WEST SUSSEX COUNTY COUNCIL CONSULTATION

TO:	Arun District Council FAO: Amy Myer
FROM:	WSCC - Highways Authority
DATE:	17 November 2021
LOCATION:	Land adjacent to Church Farm Barn, Horsemere Green Lane, Climping, BN17 5QZ
SUBJECT:	CM/64/21/PL Use of land for Class B8 (Storage) for caravan storage. This application may affect the setting of listed buildings & is in CIL Zone 3 (Zero Rated) as other development.
DATE OF SITE VISIT:	N/A
RECOMMENDATION:	Advice
S106 CONTRIBUTION TOTAL:	N/A

Swept Path Analysis

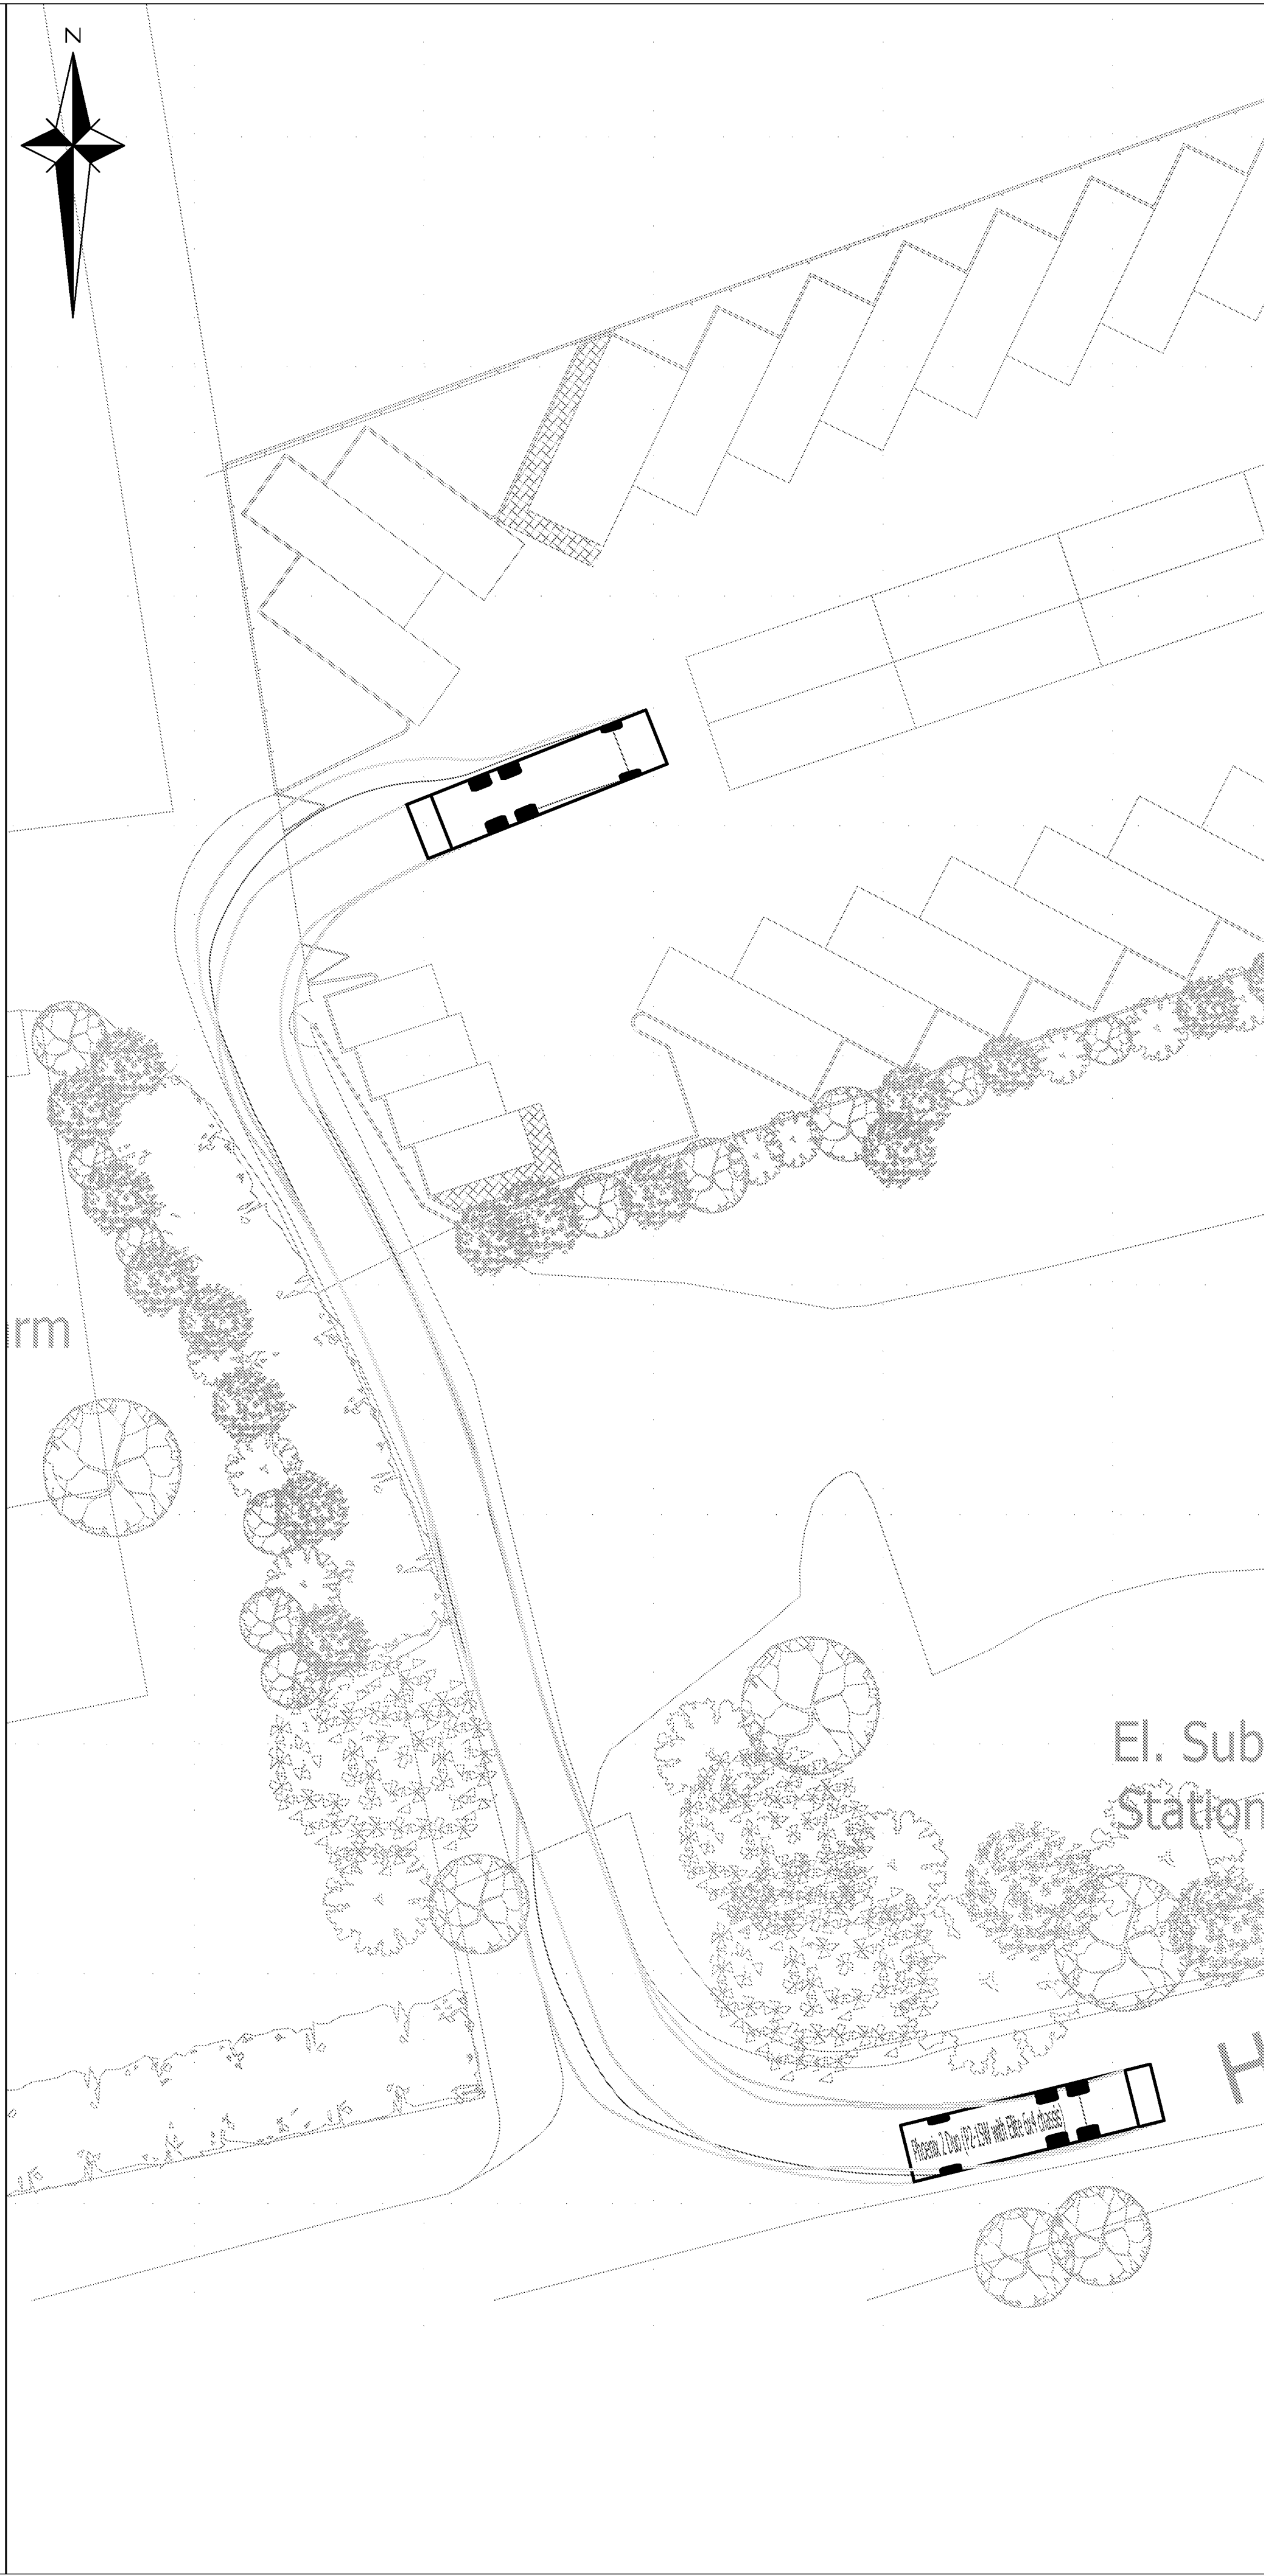
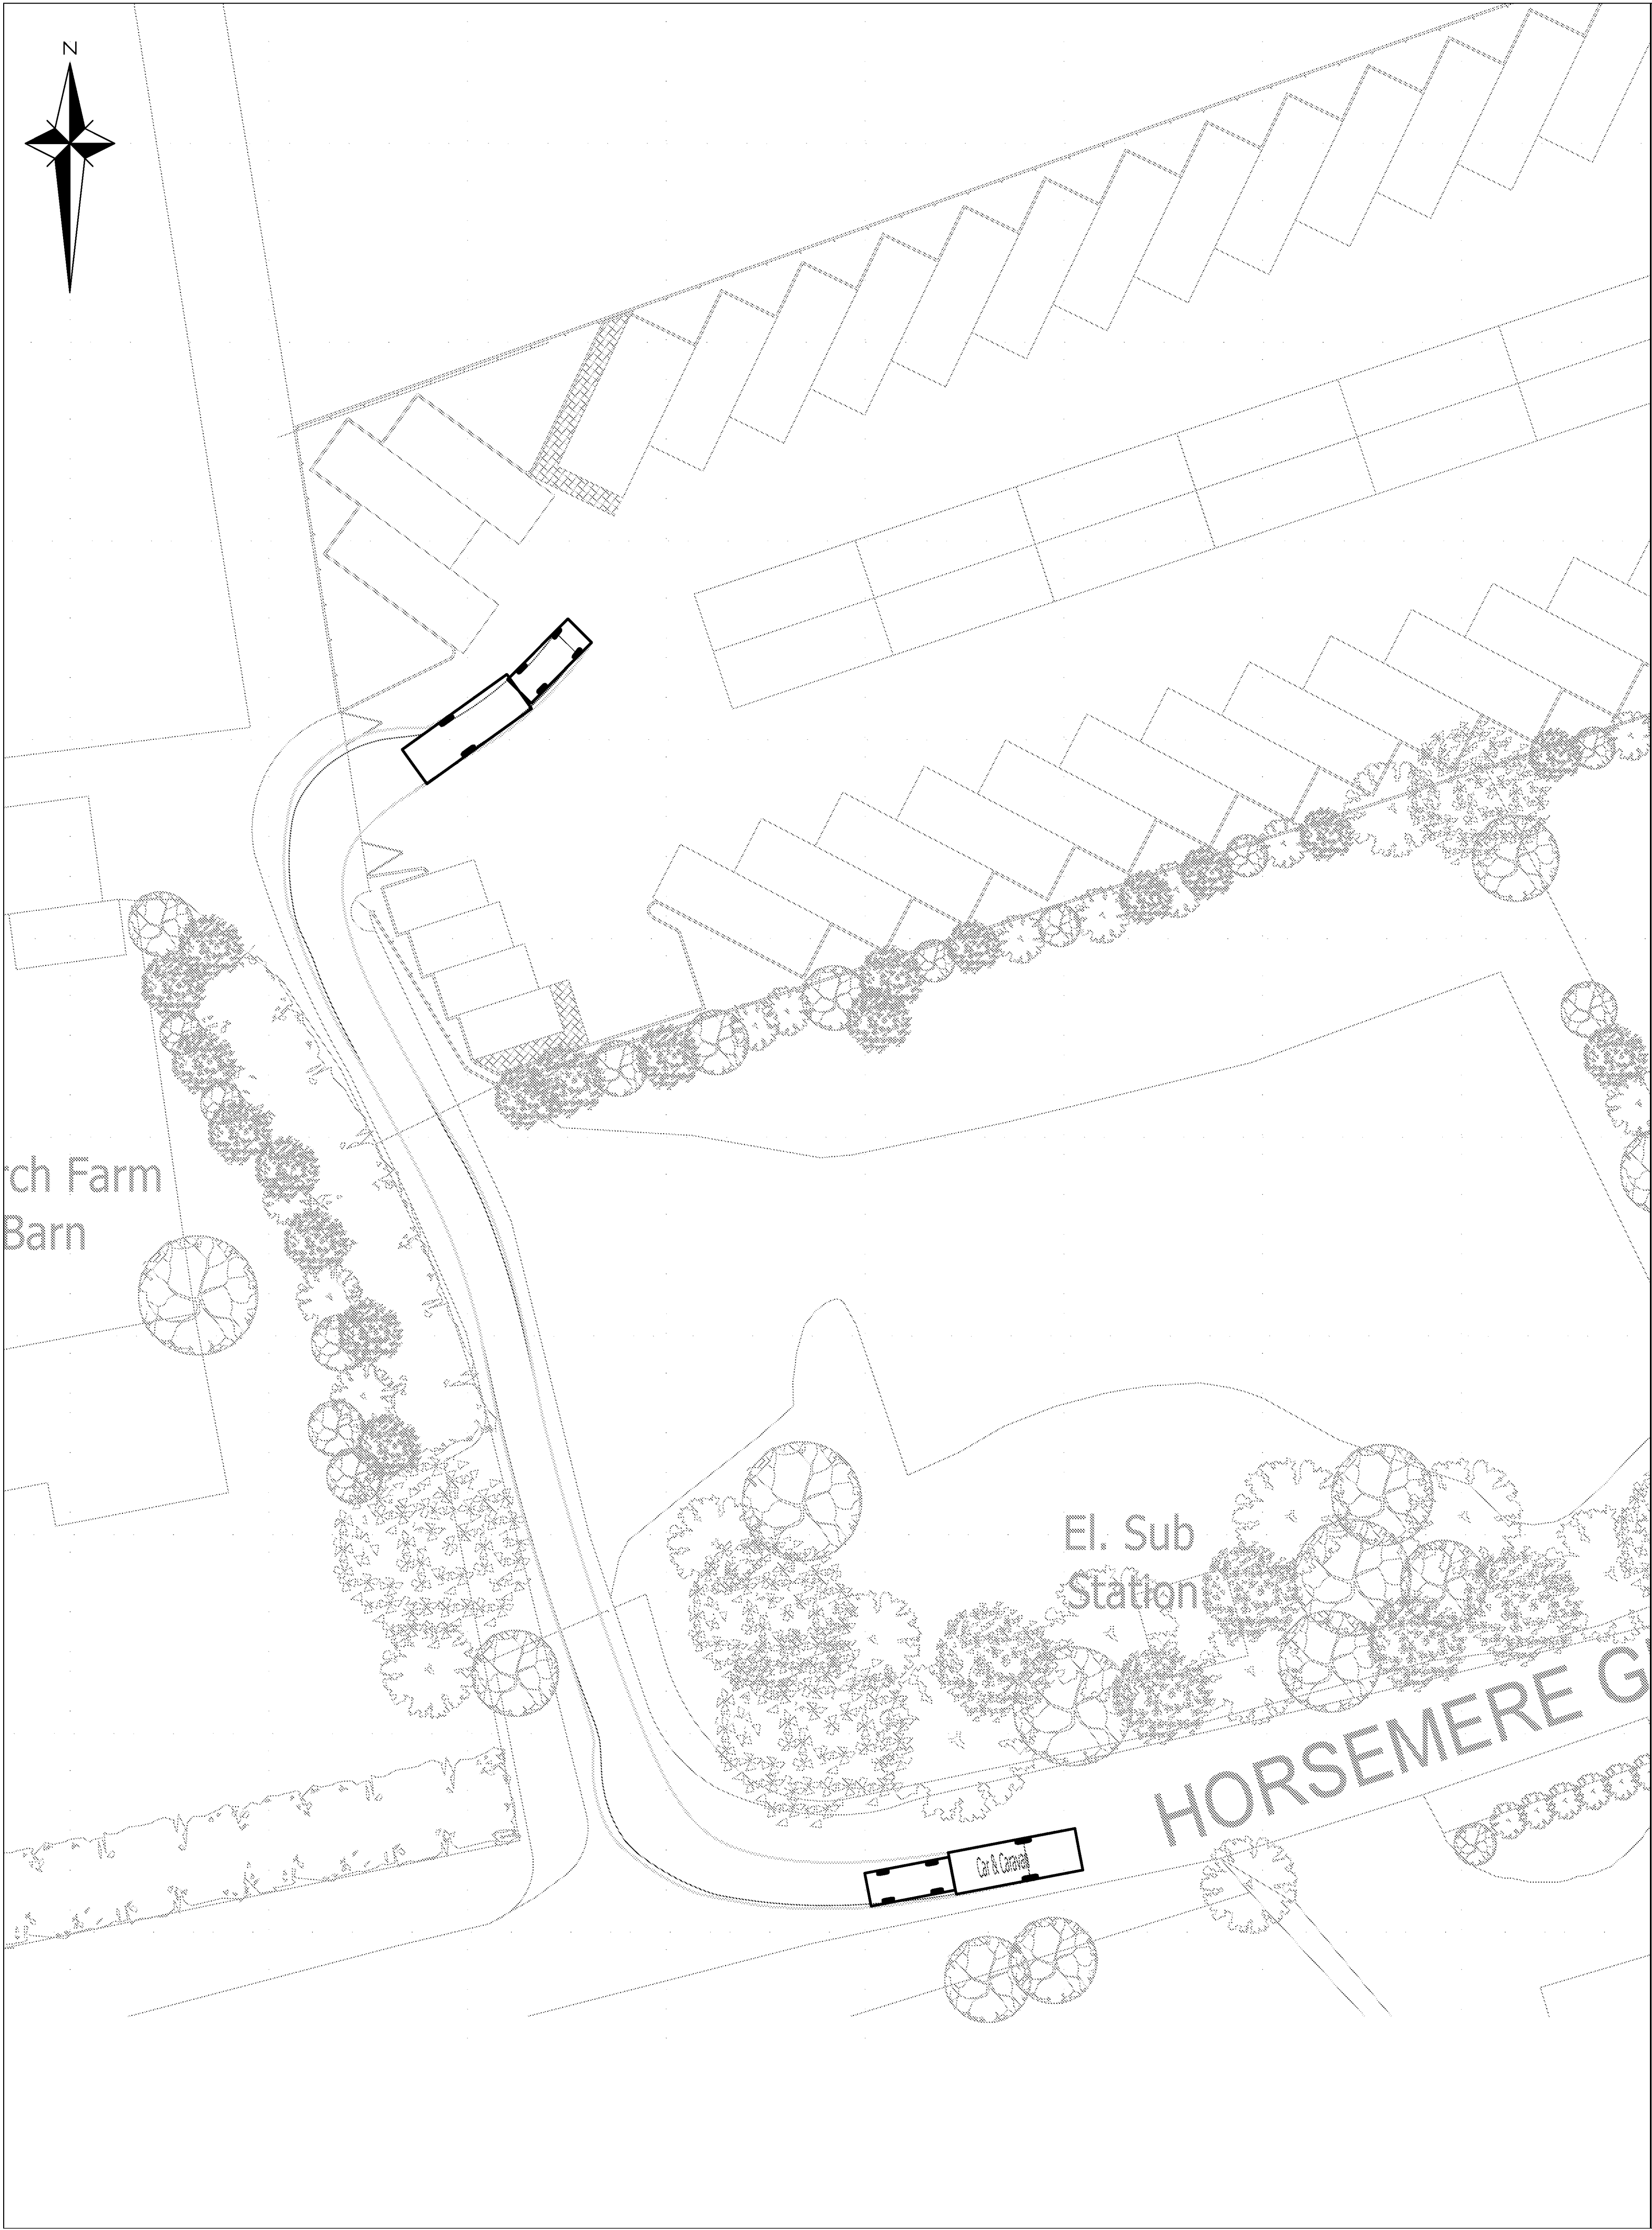
The site will accommodate up to 46 caravans, with provision for four car parking spaces. The LHA anticipates that four car parking spaces will be adequate for a development of this size. From inspection of the plans, the proposed parking bays are suitably sized and on-site turning for a car towing a caravan has been demonstrated via swept path tracking.
